**Advice on Response to Submissions – State Significant Development – Alterations and additions to Kincoppal-Rose Bay School (SSD-10325)**

**Jackie Taylor**  
**Senior Team Leader, Aboriginal Cultural Heritage Regulation - South**  
**Heritage NSW**  
2 August 2021

B11 SITE SECTION

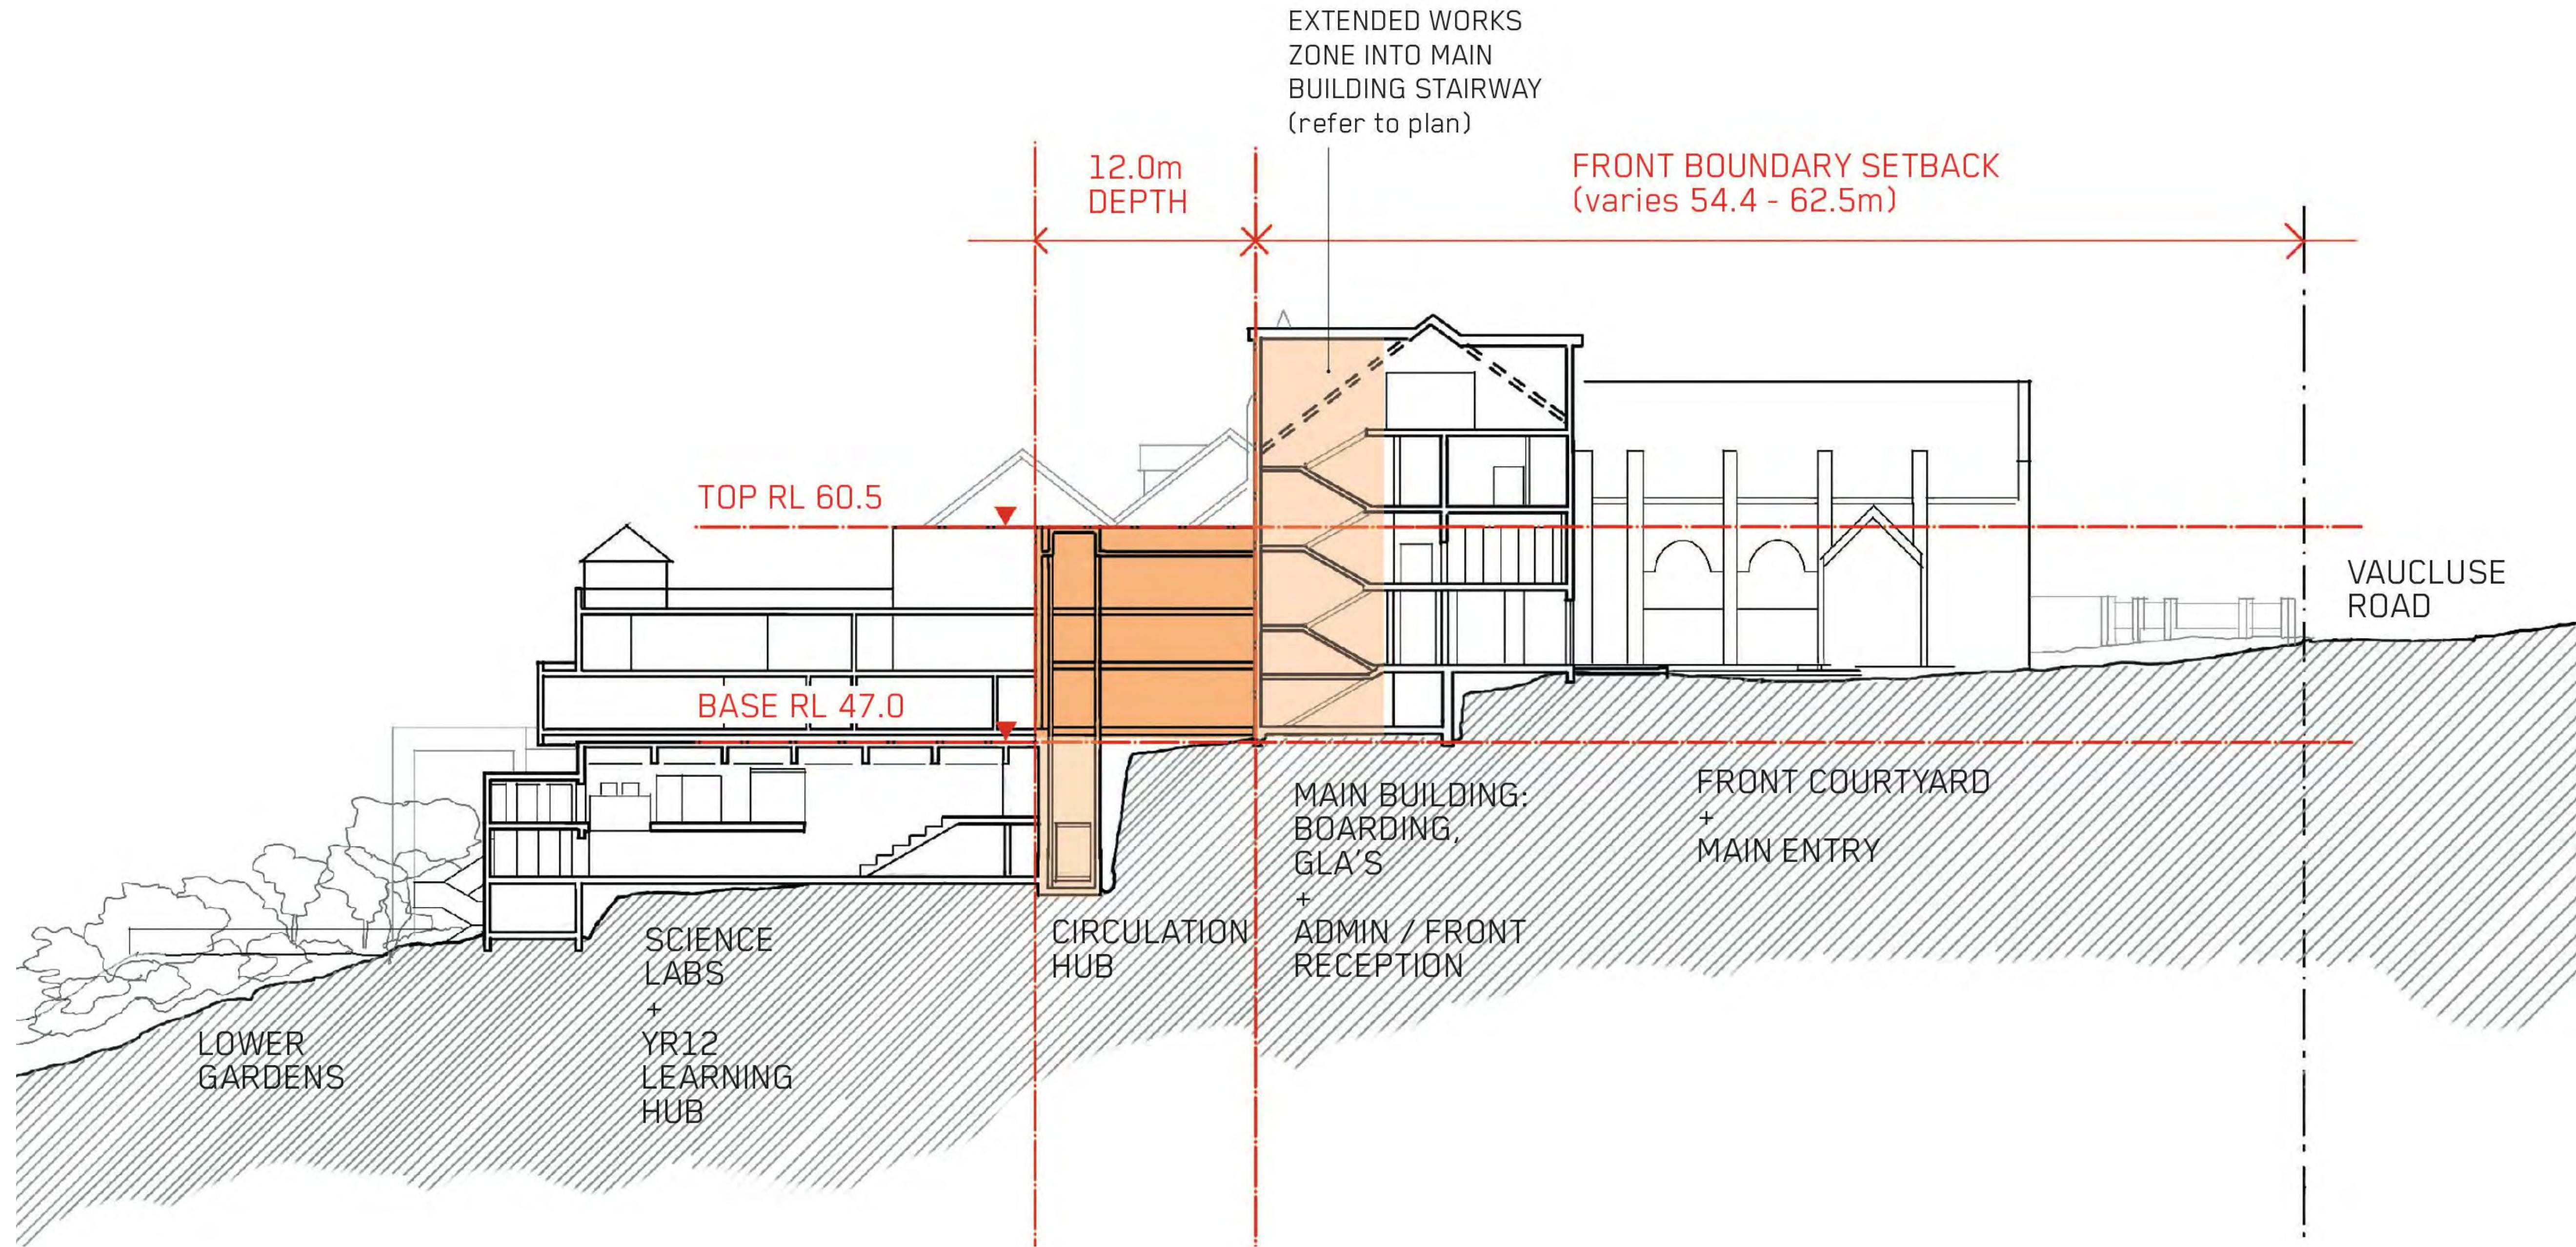
The revised Construction Management Plan does not however, reference Aboriginal cultural heritage or include policies to manage or avoid impacts to Aboriginal cultural heritage within the subject area during construction. No detailed plans have been submitted for the design of the proposed Boarding Accommodation building near AHIMS site #45-6-3754. The concept drawings included as Appendix D4 show a cross section of the proposed building located in close proximity to AHIMS site #45-6-3754.

- Consideration of the potential impacts (immediate and long term) to AHIMS site #45-6-3754 based on the location and construction requirements of the proposed Boarding Accommodation building. Potential impacts associated with vibration caused during piling of footings should also be considered.
